CITY OF ALBUQUERQUE

**RE: Lot 26 Block 6 Unit 22 Volcano Cliffs SAD 228
6209 Papagayo NW
Grading and Drainage Plan
Engineers Stamp Date 2/22/18 (D10D003B14)**

Based upon the information provided in your submittal received 9/26/17, this plan cannot be approved for Grading Permit until the following comments are addressed.

ENGINEER'S SEAL 2/28/18 DAVID SOULE P.E. #14522	6212 CAMINO ALTO CT NW WALTON RESIDENCE	DRAWN By WCVJ
	GRADING AND DRAINAGE PLAN	DATE 2-28-18 21844-LAYOUT-1-05-18
 Rio Grande Engineering 1606 CENTRAL AVENUE SE SUITE 201 ALBUQUERQUE, NM 87106 (505) 872-5998		SHEET # —
		JOB # 21844

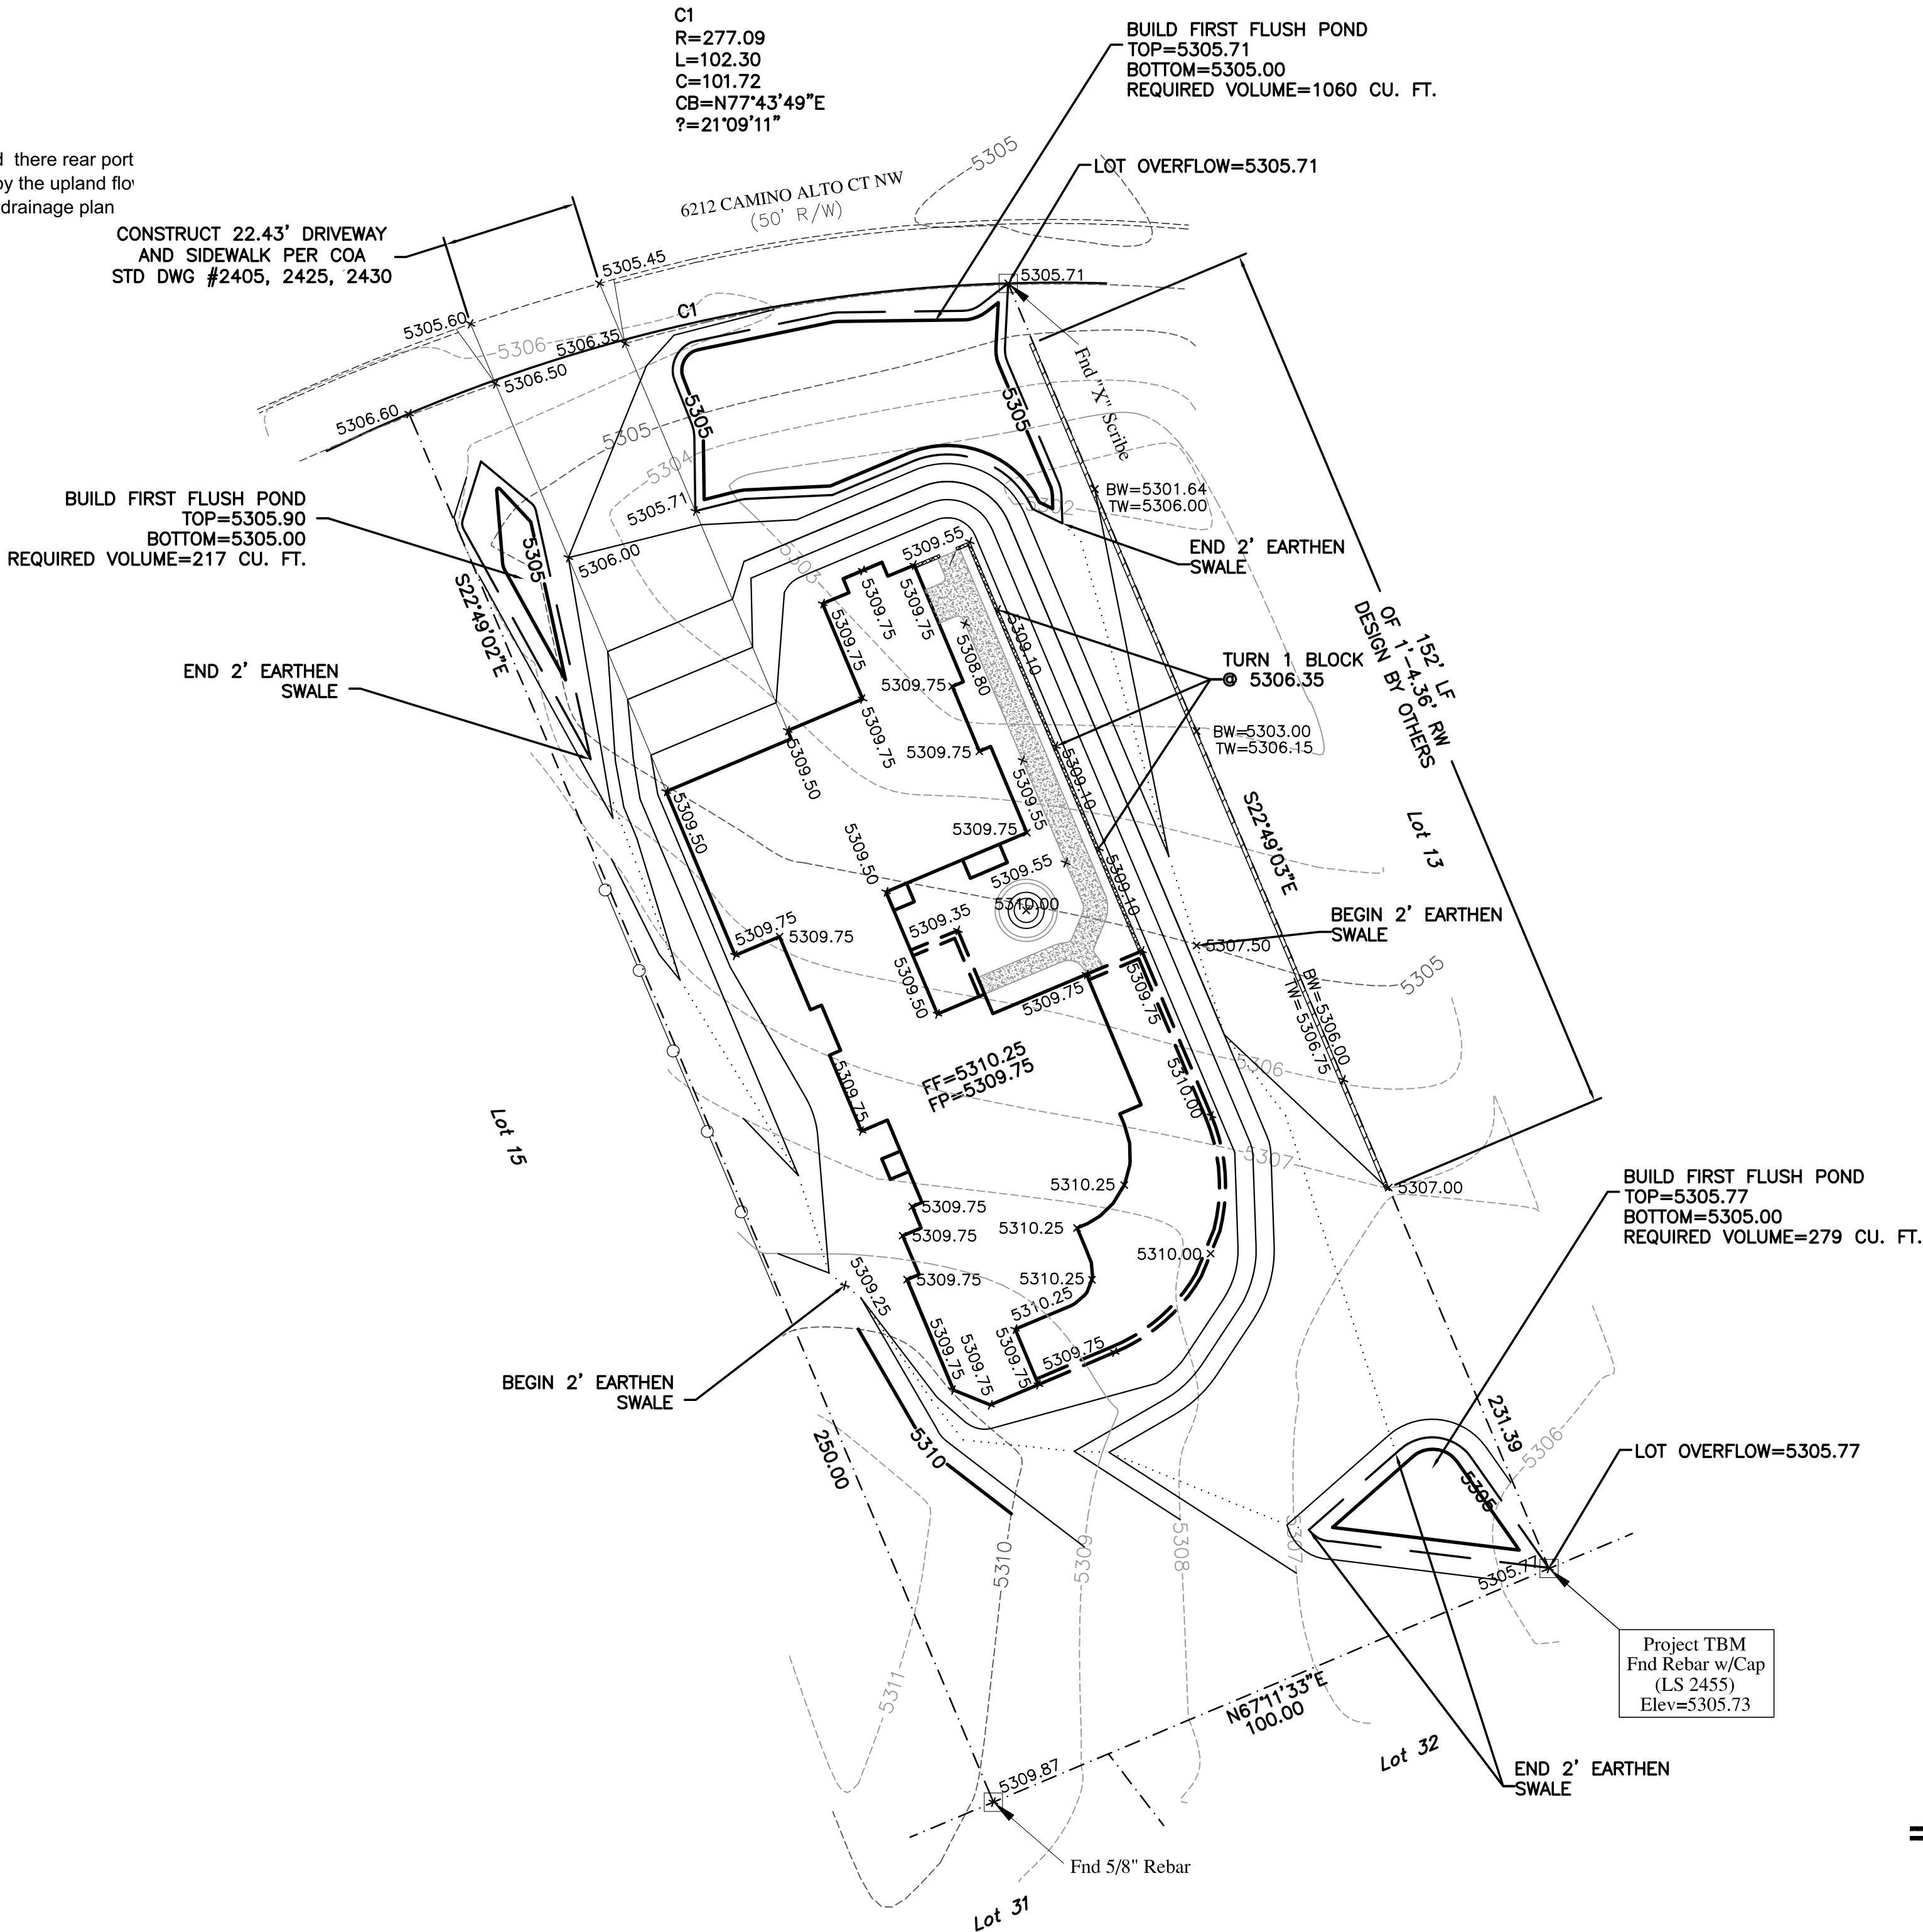
- Building Pad level too high.
- Show how runoff will make it to the pond.
